Outline Planning Application EG/108/17/OUT for a chalet style bungalow in the garden of 10 Downview Road, Barnham.

Letter of Objection

Indicative Design

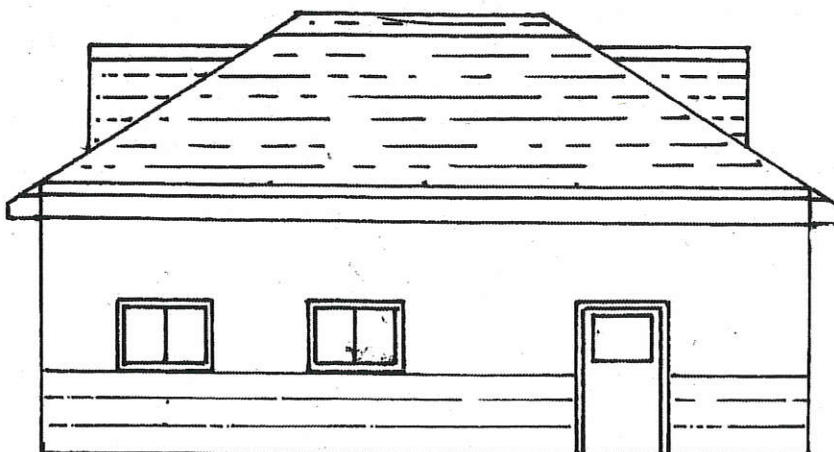
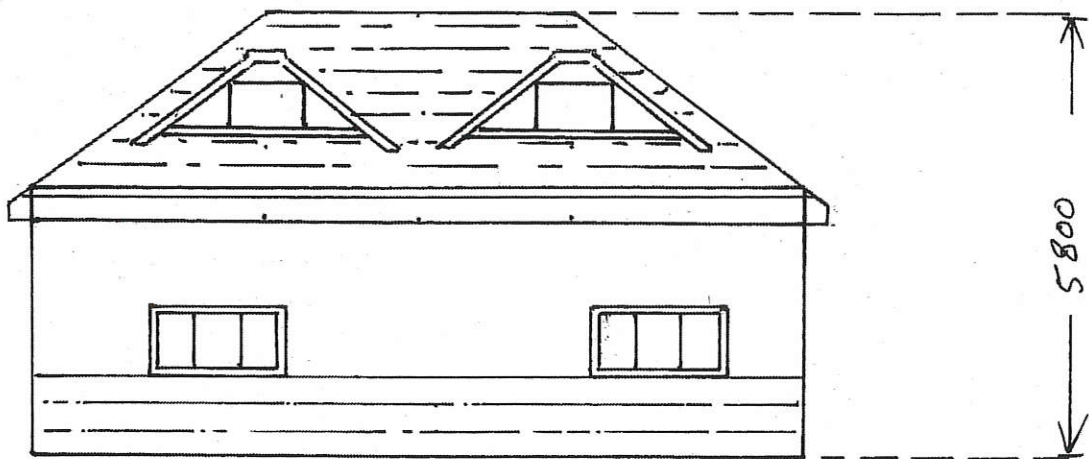
1. The proposed building will significantly impact our property, from both a visual perspective and the additional noise generated. It will be highly visible from our bedrooms, and will overlook our garden. We understand that the new owner intends for the trees at the end of his garden to remain but there is no guarantee of that of course, particularly after that plot has been sold off. The revised plan shows the screening planting between No 10 and the proposed bungalow being moved some 5m to the east, however this will increase the visibility of the new bungalow from our bedroom windows (increased angle subtended).

9. The proposed build is not in keeping with the prevailing structure and density of Downview Road as described in the Planning Guidance. The applicant's quoted figure of 14 houses per hectare applies to the new-build estate to the west of Downview Road and is not applicable to the established community of Downview Road and Elm Grove. Furthermore, the applicant states that *'the proposed dwelling has not been 'squeezed' into the plot'*. I consider this to be a misleading statement since, relative to the density of the Downview Road houses, the proposed building will indeed need to be 'squeezed' into the available site.
